Our Ref: 241745-C1

**RE: ALSPEC STORAGE AND DISTRIBUTION WAREHOUSE – Lot 11
221-227 & 289-317 LUDDENHAM ROAD, ORCHARD HILLS, NSW
CIVIL ENGINEERING - RESPONSE TO SSDA RFI [01]**

Refer to the below request for information which has been received from the Department of Climate Change, Energy, the Environment and Water in relation to the aforementioned project.

EASTERN CATCHMENT TOTAL SITE =54,354m²

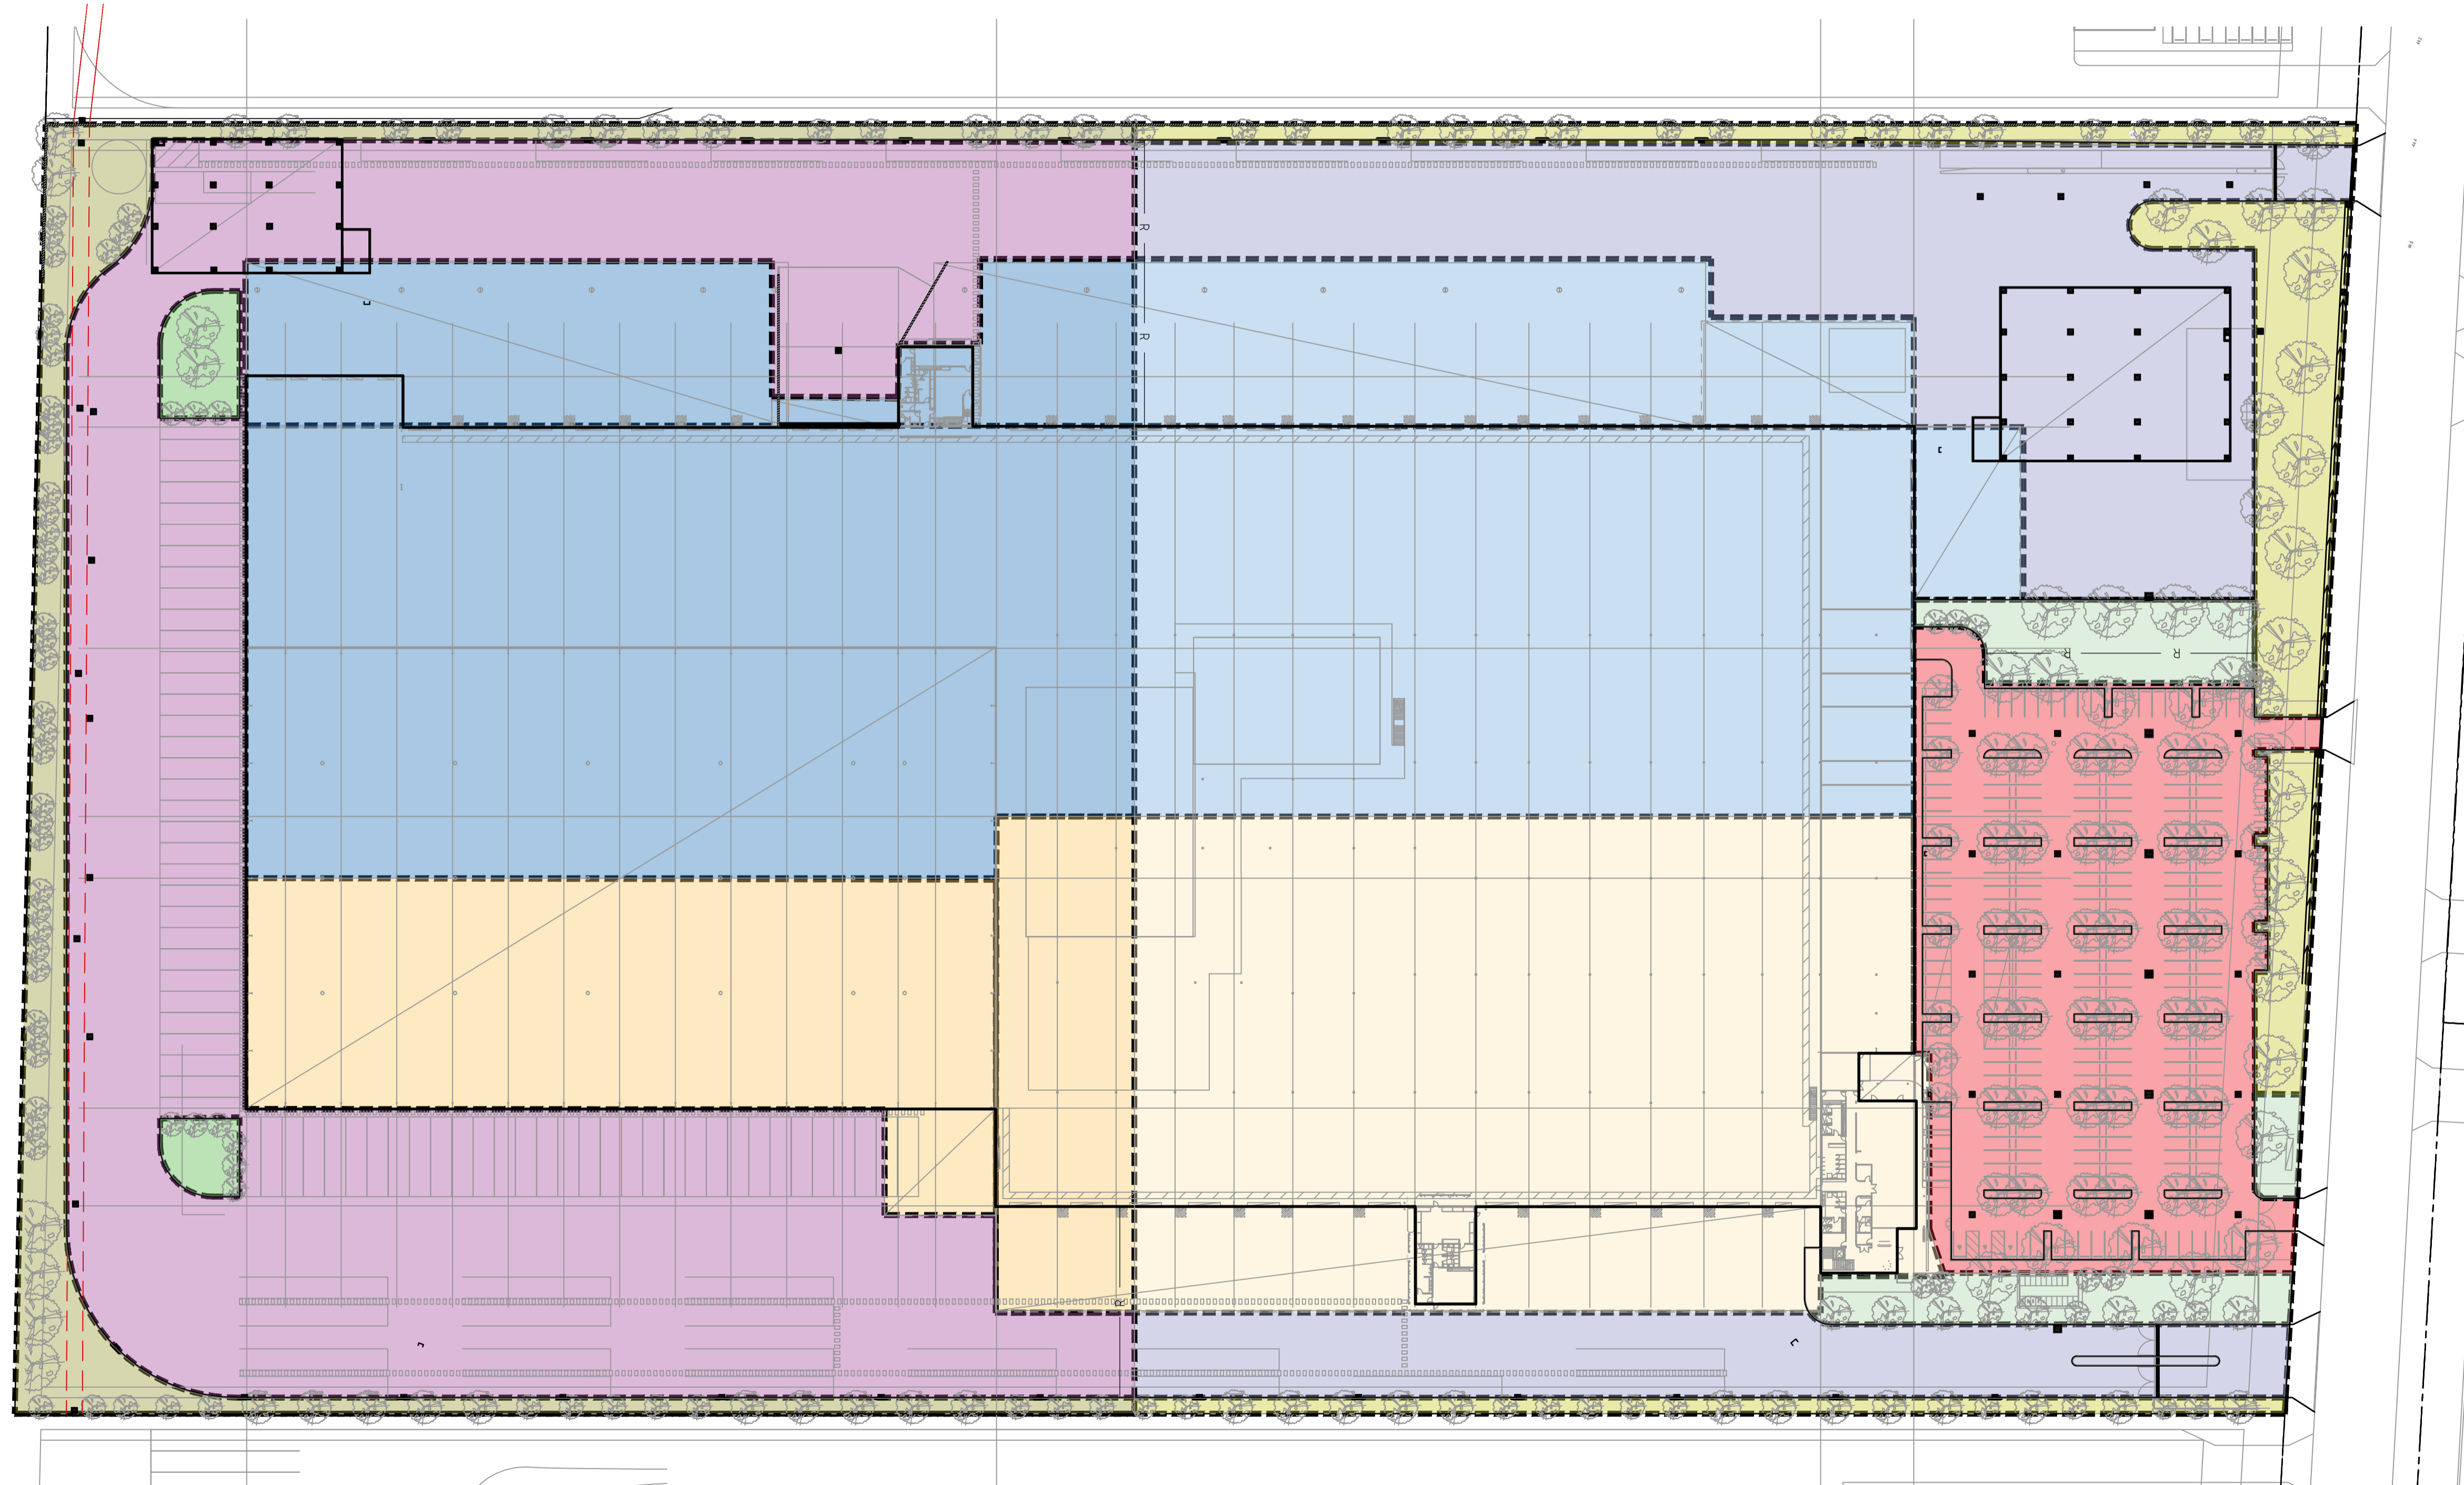
The applicant should provide a MUSIC model for this specific SSD application that includes both the interim and ultimate stormwater strategy for the construction of this warehouse. The applicant must demonstrate how the Alspec Warehouse fits into the business park stormwater strategy, and that waterway health targets will be met.

Detailed design and civil drawings for this SSD, that align with the MUSIC model and a Water and Stormwater management plan for this SSD are also required. The elements modelled in the MUSIC Model should also be included in the water and stormwater management plan. All pertinent information required are found in the Tech Guide.

A MUSIC model for the AIBP estate has been prepared, which incorporates the design for the Alspec Storage and Distribution Warehouse on Lot 11. The results of the MUSIC model have been summarised below. The model is consistent with the approved MUSIC model that was prepared at the DA stage for the AIBP subdivision works.

The MUSC model has been setup as per Figure 1 below. The pit schedule on drawing 241745_DA_C200 Revision 3 has been updated to clarify that pit baskets are required in each inlet pit within the subject site.
